Great Yarmouth Third River Crossing Order 202[*]

Document NCC/GY3RC/EX/046: Proposed Changes Application

Document Reference: NCC/GY3RC/EX/046

Date: 11 December 2019

DRAWING NUMBER
GYTRC-NCC-HGN-XX-DR-CB-1010

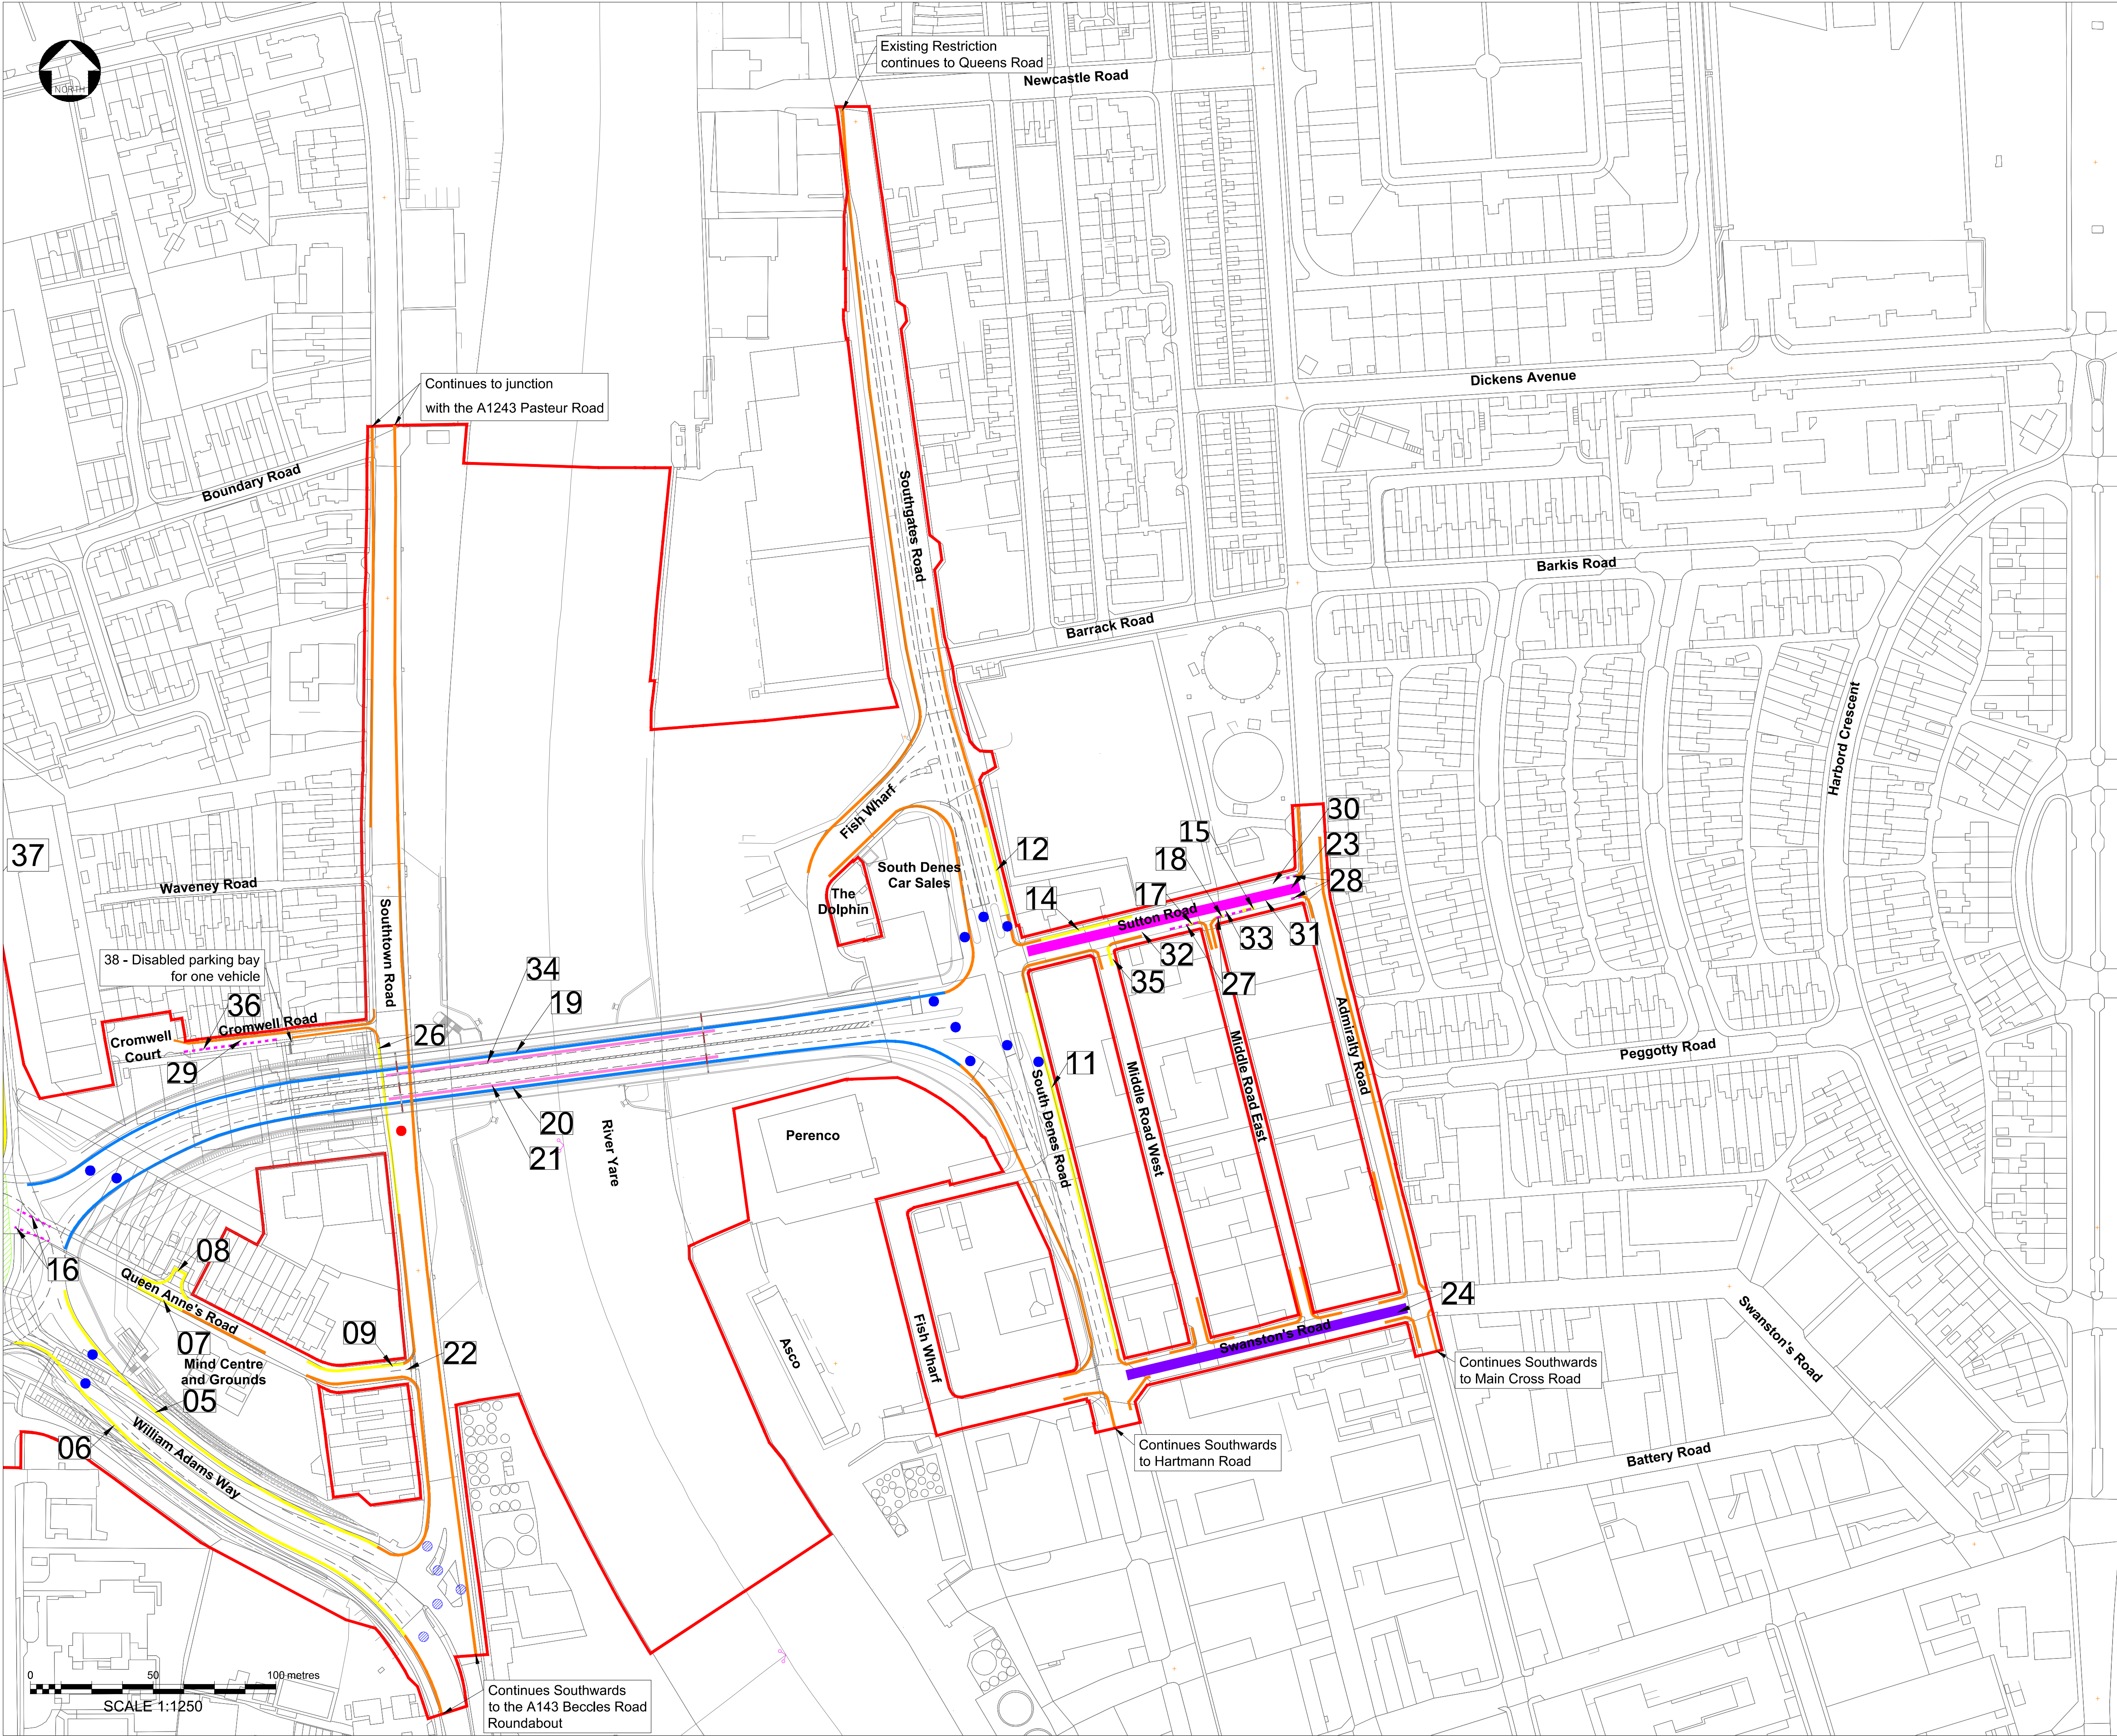
- Removal of the 'no waiting at any time' restriction proposed in the DCO Application (identified as Traffic Regulation Measure Reference Number 10 on the Traffic Regulation Measures Plans, on Sheet 2 of 2 (Document Reference 2.3, Planning Inspectorate Reference APP-008)) on the east side of A1243 Southgates Road from a point 21 metres north of the mid-point of its junction with the U60757 Barrack Road northwards for a distance of 50 metres;

- Removal of the limited waiting Monday to Saturday between 8am and 6pm (1 hour maximum waiting period, no return within 2 hours) restriction proposed in the DCO Application (identified as Traffic Regulation Measure Reference Number 13 on the Traffic Regulation Measures Plans, on Sheet 2 of 2 (Document Reference 2.3, Planning Inspectorate Reference APP-008)) on the east side of A1243 Southgates Road from a point 71 metres north of the mid-point of its junction with the U60757 Barrack Road northwards for a distance of 27 metres.

2.2.2 Figure 2.1 shows 'before' and 'after' excerpts from the Traffic Regulation Measures Plans, Sheet 2 of 2 (Document Reference 2.3, Planning Inspectorate Reference APP-008), to show the changes that would be effected to Traffic Regulation Measures References 10 and 13, if proposed NMC 1 was accepted by the Examining Authority.
